Re: Planning Application 19/0551

Address: Grove House Malt Kiln Brow Chipping PR3 2GP

Description: Demolition of existing lean-to garage and potting shed and replacement with double garage with workshop and storage above. Construction of single story extension to side and single-story glazed link between the existing kitchen and wash house. Re-point with lime mortar and repair and replace cast-iron guttering (like for like).

PROPOSED SITE PLAN
Scale 1:500

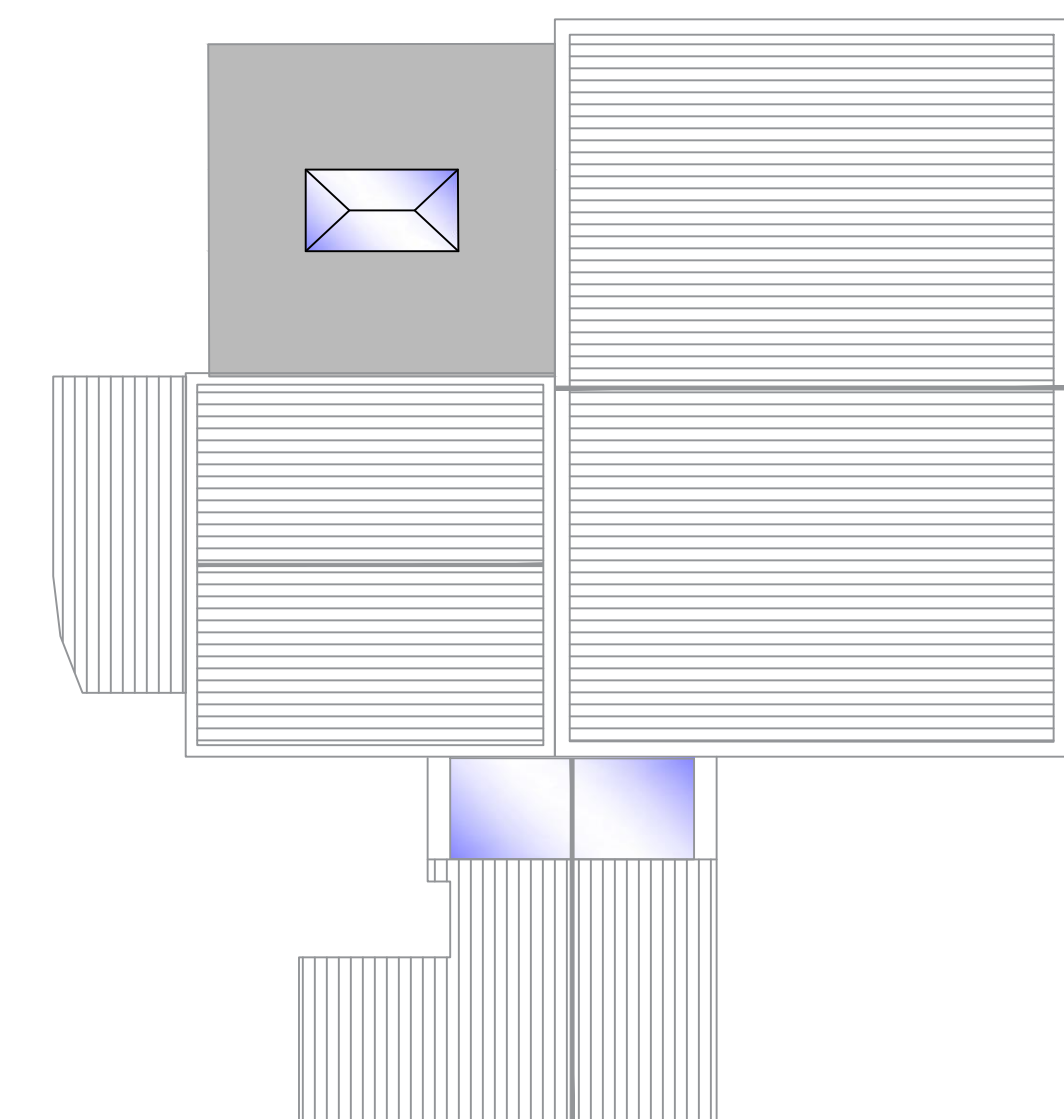
In line with the Lancashire Parking Standards a 4 bedroomed house such as this should have 3 car parking spaces. It is noted that the proposed garage would not be considered large enough to constitute a car parking space. However it would appear that there is sufficient car parking to accommodate 3 off street car parking spaces. If at some point in the future the use of the garage is changed to some form of accommodation there is a concern that this compromise the parking standards.

or any subsequent Orders or statutory provision re-enacting the provisions of these Orders, all garages shown on the approved plan shall be maintained as such and shall not be converted to or used for living accommodation without the prior written approval of the Local Planning Authority in consultation with the Highway Authority. **Reasons:** To allow for the effective use of the parking areas.
